TRI-STATE GENERATION & TRANSMISSION, INC.

FOX RUN SUBSTATION FINAL DRAINAGE REPORT

PCD FILE # PPR-22-044

October 11, 2022

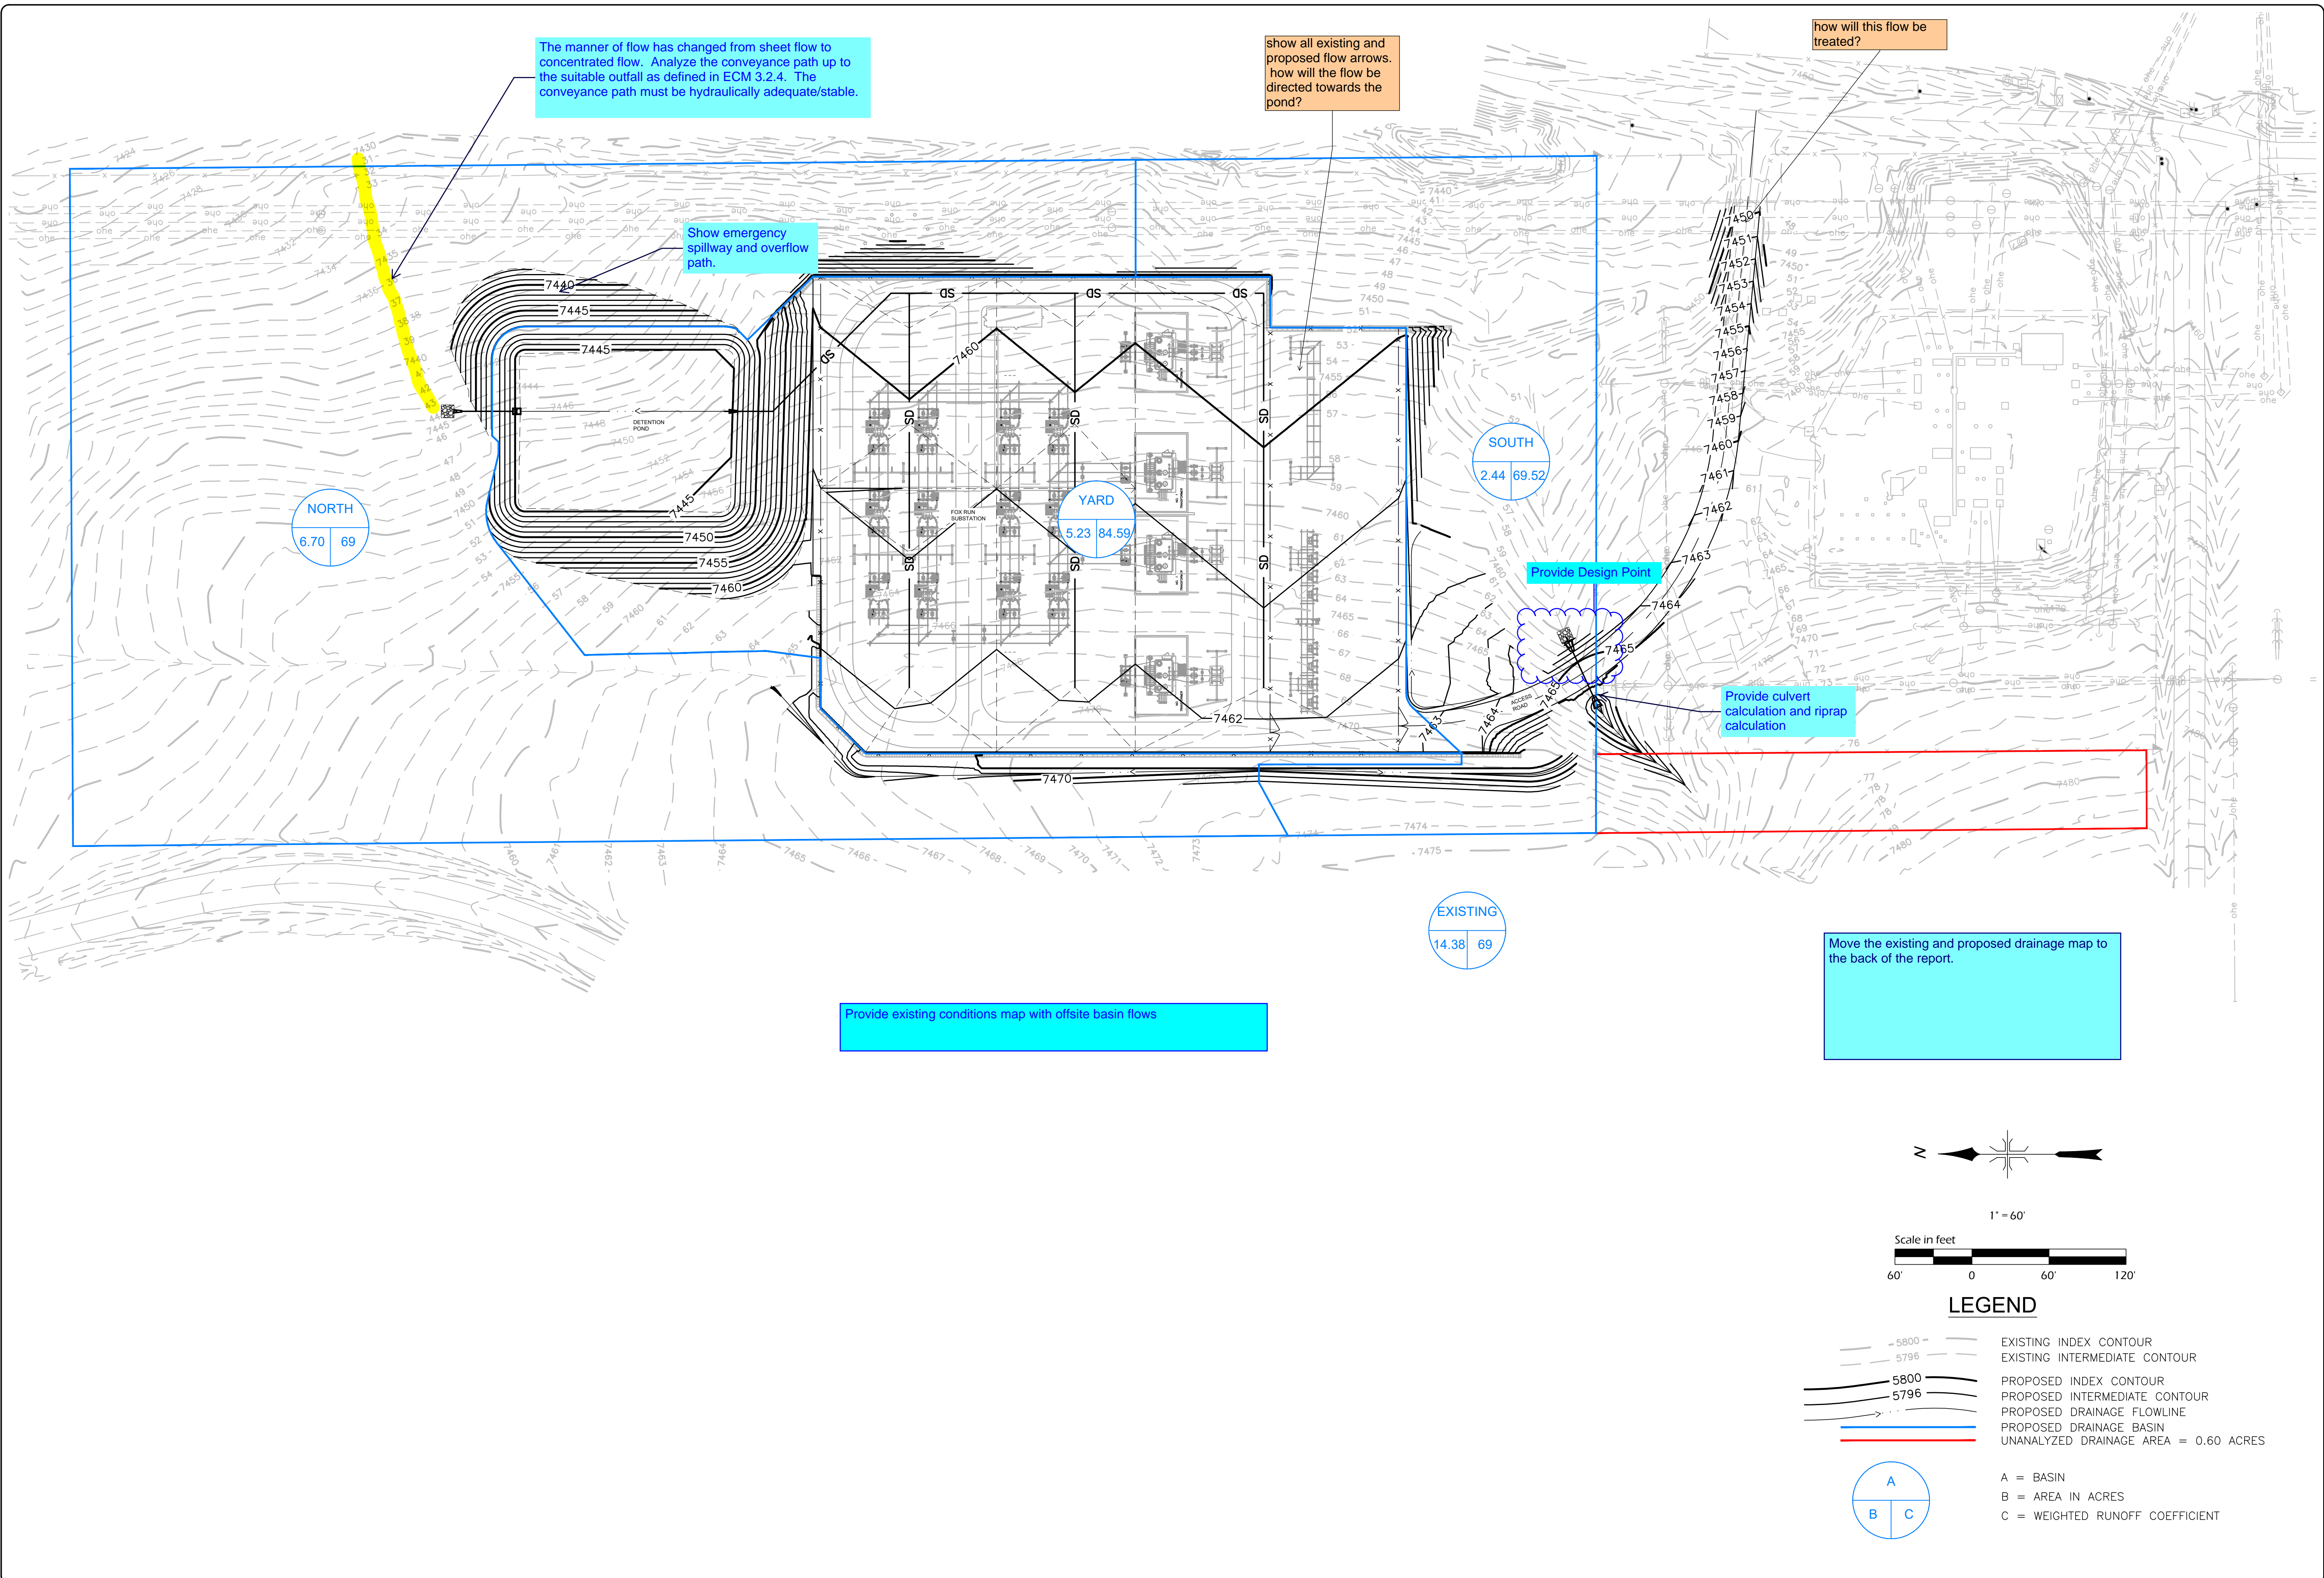
The manner of flow from sheet flow to concentrated flow. Analyze the conveyance path up to the suitable outfall as defined in ECM 3.2.4. The conveyance path must be hydraulically adequate/stable.

Unresolved. Add a paragraph or section in the Drainage Facility design summarizing the results.

- Identify the velocity along the highlighted section and state whether it's within the permissible non-erosive velocity for the given soil, ground cover, and slope. Mitigation will be required if the concentrated pond discharge is likely to erode the existing ground downstream of the proposed swale. Contact the review engineer to discuss if additional clarification is required.

Determine if this a suitable outfall. Where will the overflow be directed?

provide riprap sizing calculation in the appendix.

**DRAINAGE BASIN DELINEATION**

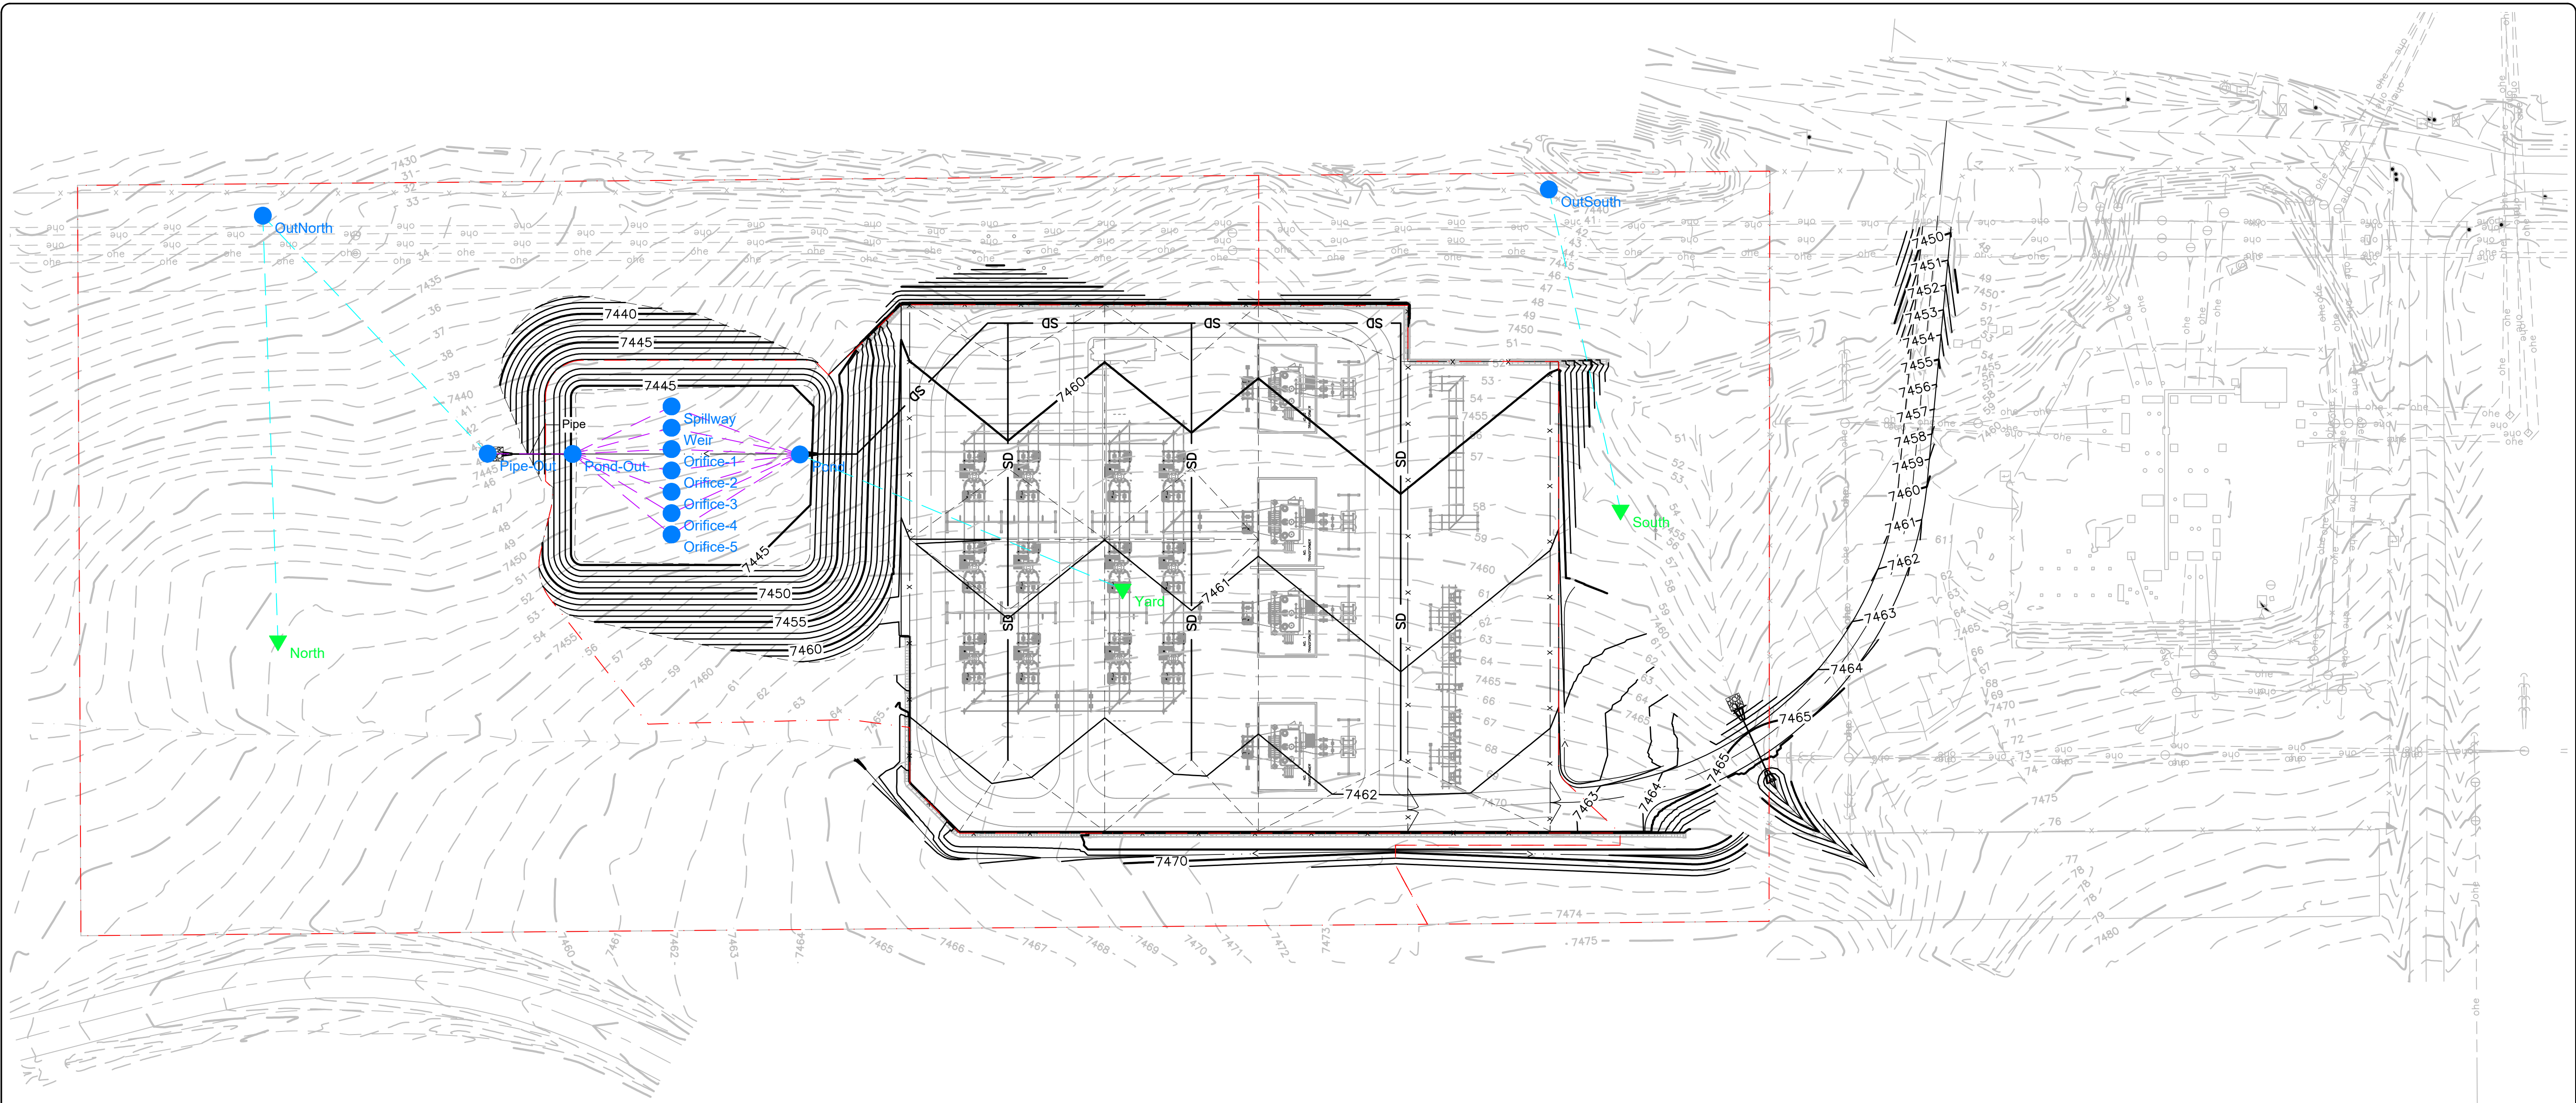
show existing flow arrows unresolved.

There are basins that are not being captured by the proposed ponds. Explain in the narrative how WQ is being addressed for these basins. Possible exclusions include I.7.1.B.7 (land disturbance to undeveloped land that will remain undeveloped) and/or I.7.1.C.1 (which allows for 20% not to exceed 1 acre of the applicable development site area to not be captured).

include basin for this disturbance and WQ

Provide existing conditions map with offsite basin flows
Unresolved - ddschoenheit
12/08/2022 7:28:55 AM

Existing conditions and basin map should show parcel without new structures and development. Show flow arrows pre-development

Please move drainage maps to end of report
Unresolved - ddschoenheit
12/08/2022 10:53:09 AM
